Fwd: Congress at Valley - Turn lane questions

Will/Steve/et al.,

Below are some general comments on the concept you sent at the beginning of the month, developed by Mike and Bruce in conjunction with Jeremiah, me, and Tom Errico. Please let me know if you have questions.

CONGRESS STREET

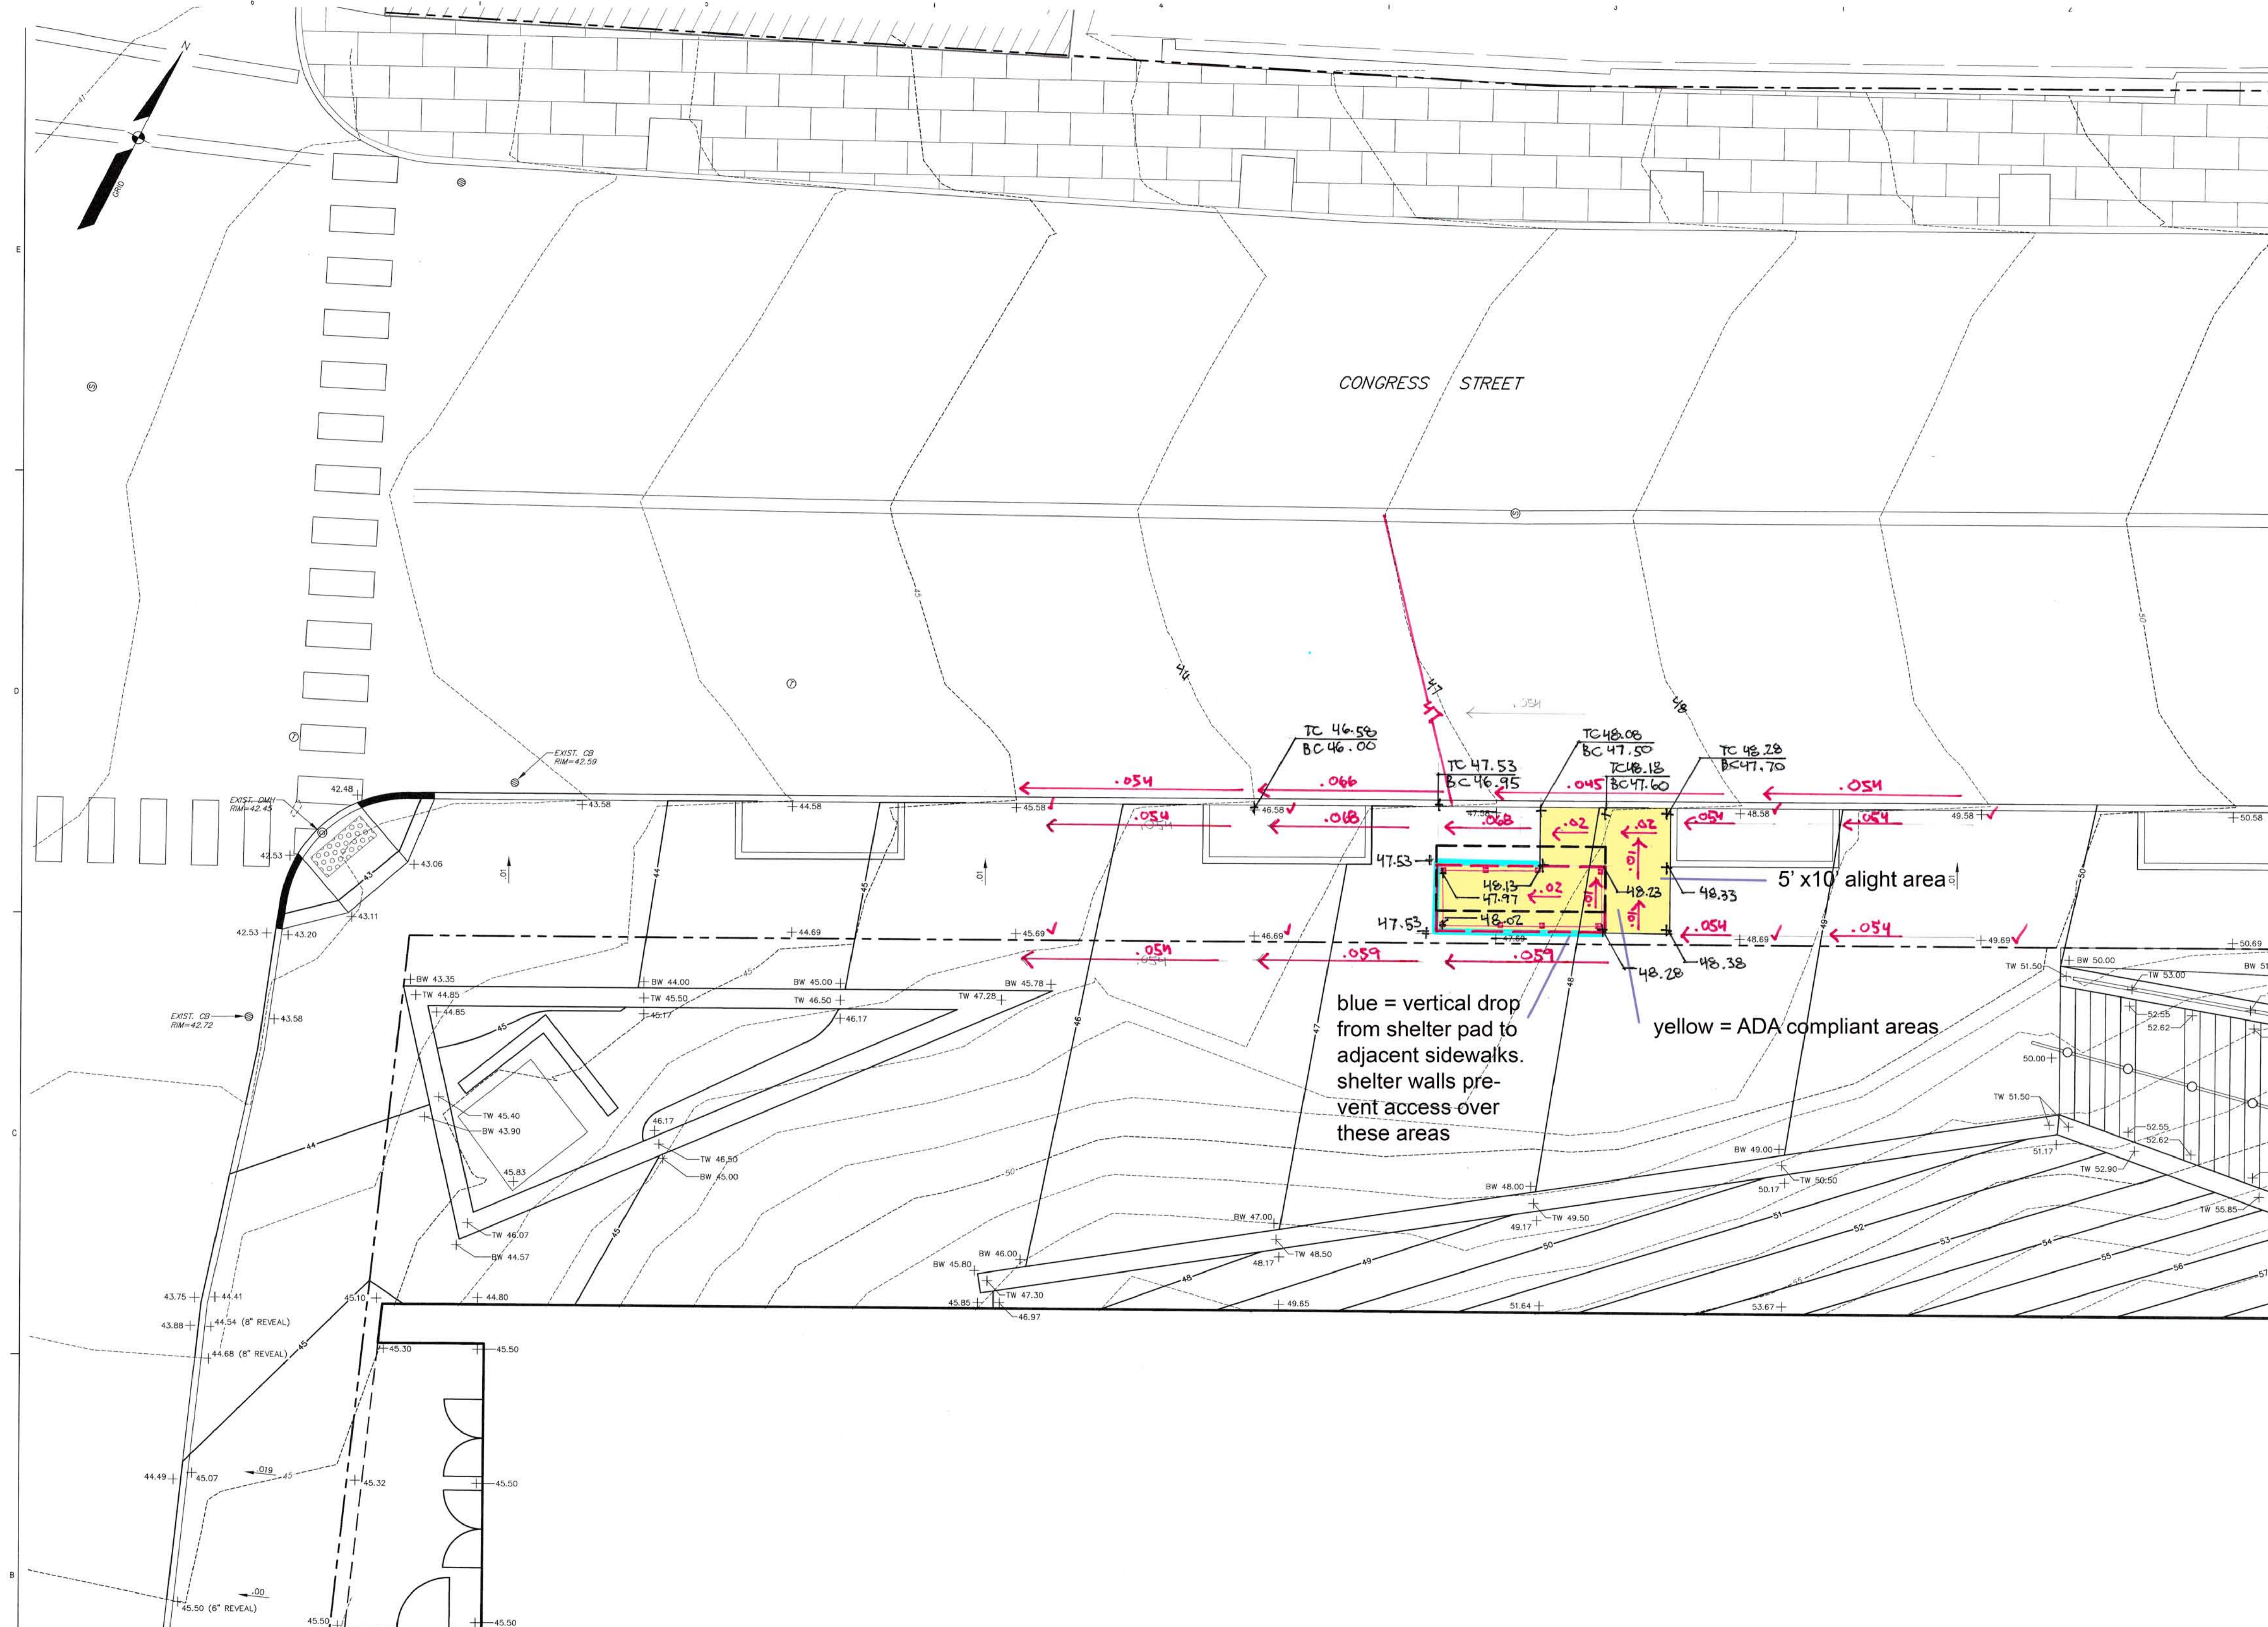
- The concept does not appear to reflect the work done up to the Planning Board's approval with conditions that include moving the southerly curb line of Congress Street from Gilman to the Visitor's Garage entrance out ~4' to enable the bus stop/bus shelter to be ADA compliant and have enough room behind the shelter for pedestrian access.
